CITY OF PORTLAND

RE: 42 Washington Avenue – 013-E-015 – B-2b Zone

I am in receipt of your building permit to erect a 14' x 22' deck on the rear of the existing restaurant. **Your permit is being denied** because it can not meet the current zoning requirements.

BOUNDARY & TOPOGRAPHIC SURVEY
ON
WASHINGTON AVENUE, PORTLAND, MAINE
MADE FOR RECORD OWNERS
MICHELLE A. KELLEY
38 WASHINGTON AVENUE, PORTLAND, MAINE
EPS BEAGLE, LLC
40 WASHINGTON AVENUE, PORTLAND, MAINE

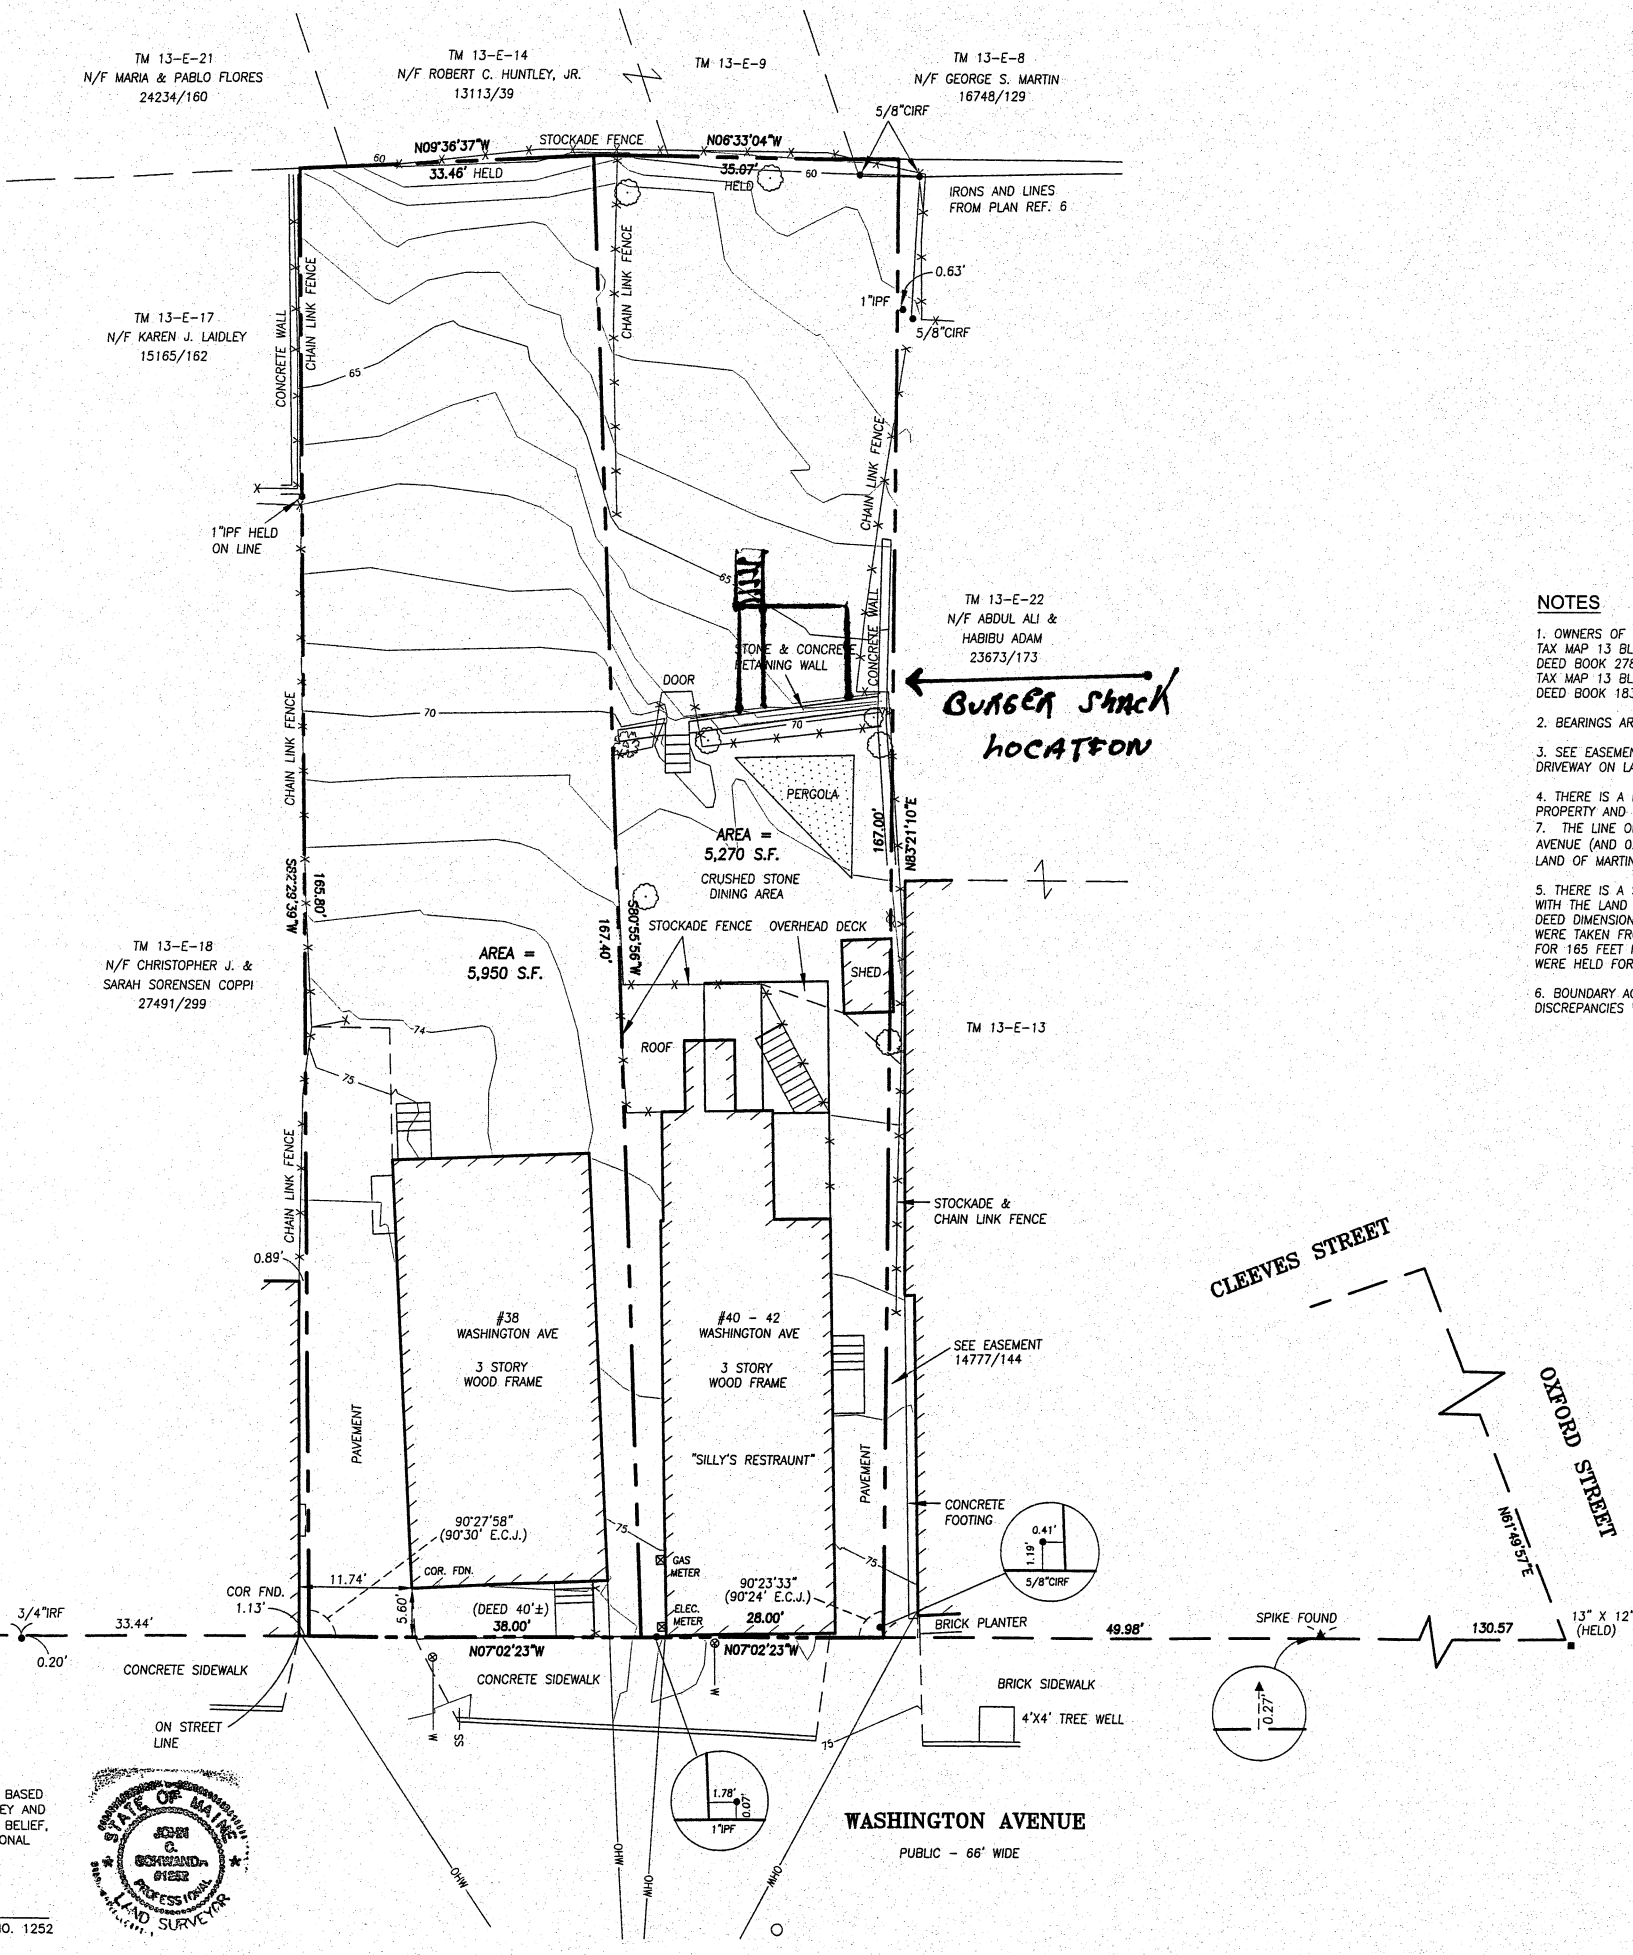
The B-2b Business zone states that there is no requirement for a setback from the property line except when the side line abuts a first floor residential zone or a residential use, then a ten (10) foot setback is required (section 14-185). The left hand side of your building abuts a first floor residential use. Your plans show that you have only a one (1) foot setback instead of the ten (10) foot setback required.

The zoning requirements also require off-street parking based on the increase square footage (section 14-332). Your submitted plot plan shows no increased parking for the new public deck. The ordinance requires 1 parking space for each 150 square feet of area. You would need to show this office at least 2 off-street parking spaces for this proposal.
